Written Representation to the Examination of

The Drovers Solar Farm DCO

Planning Inspectorate Reference: EN0110013

Document Reference:	VBPV-UK-BRF-2026-04-30-001-V1
Date:	30 April 2026
Author:	Paul Bird
Organisation:	Dual Harvest Agrivoltaics Limited
Campaign:	Harvesting the Sun Twice
Contact:	harvestingthesuntwice@gmail.com
Website:	harvestingthesuntwice.org
Submitted to:	The Planning Inspectorate — EN0110013

PINS Ref. EN0110013 Drawing no.: 9485_0538

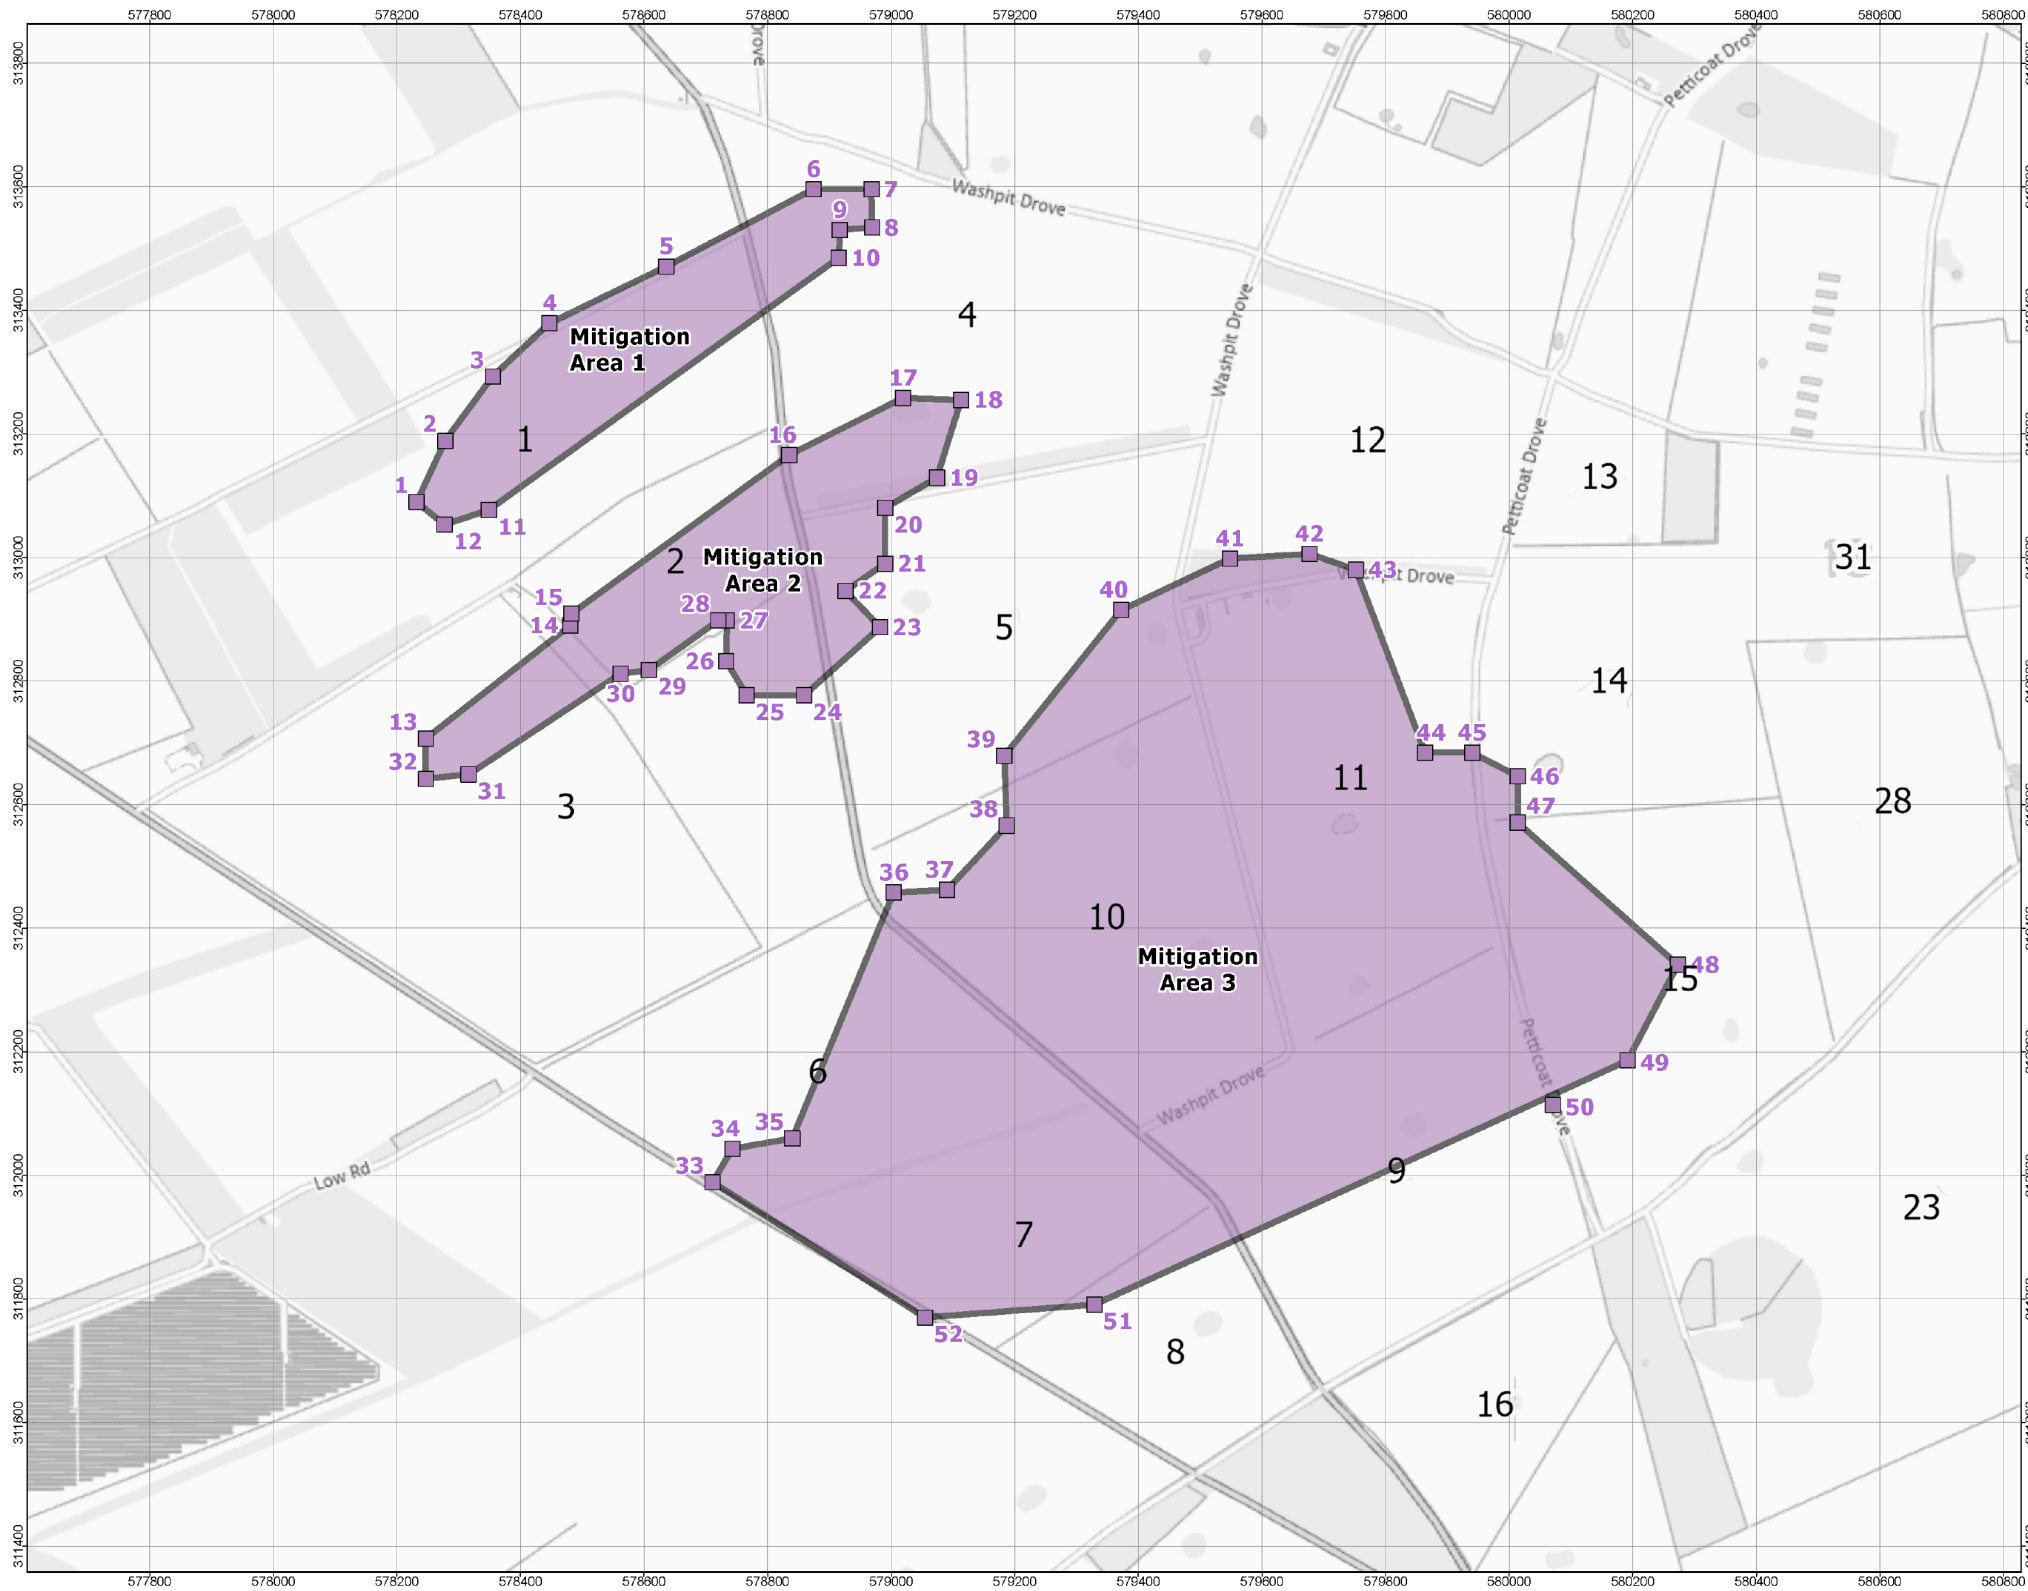
A fixed-tilt south-facing array presents a large planar reflective surface at a low elevation angle — typically 10–35 degrees from horizontal. RAF Marham's precision approach radar is positioned to the west-northwest of areas within the proposed Droves site. A TBPV array in radar line-of-sight to that radar will present a surface from which specular and near-specular reflections can redirect the radar signal along secondary paths. The MoD's objection is a direct and predictable consequence of this geometry.

A VBPV array presents its panel face perpendicular to the ground, oriented east and west. When viewed from the direction of RAF Marham's precision approach radar, a VBPV array presents its narrow structural edge — not its panel face. The coherent reflective surface area in the radar's line of sight is reduced by approximately 85–90% compared to an equivalent TBPV installation. The multi-path reflection mechanism the MoD describes requires a substantial, coherently-oriented reflective surface. That surface does not exist in a VBPV array oriented east-west.

Glint occurs when a solar panel surface produces specular reflection directed toward an observer. For a fixed-tilt south-facing array, specular glint toward a low-elevation observer — such as a pilot on final approach — occurs at specific sun angles when the panel face, the sun, and the observer are in a geometrically defined relationship. Runway 23 at RAF Marham is oriented broadly south-southwest. An aircraft on final approach to runway 23 from the northeast will, at certain times of day, be in the glint reflection zone of south-facing panels in the Droves site. The MoD's concern is geometrically well-founded for a TBPV installation.

1. Require the applicant to address, in its response to the MoD's radar and glint/glare objections, whether VBPV configuration has been assessed as an alternative to TBPV, and if so, to provide the basis for any conclusion that VBPV would not resolve the MoD's concerns;
2. Note that the MoD's objection is a configuration-specific objection, not a technology-specific objection, and that the examination of mitigation measures should include consideration of configuration change as a primary mitigation option; and
3. Consider whether a condition or requirement addressing panel orientation — specifically the option of VBPV configuration for those array sections in radar line-of-sight to RAF Marham's precision approach radar — would be appropriate in the event that consent is granted.
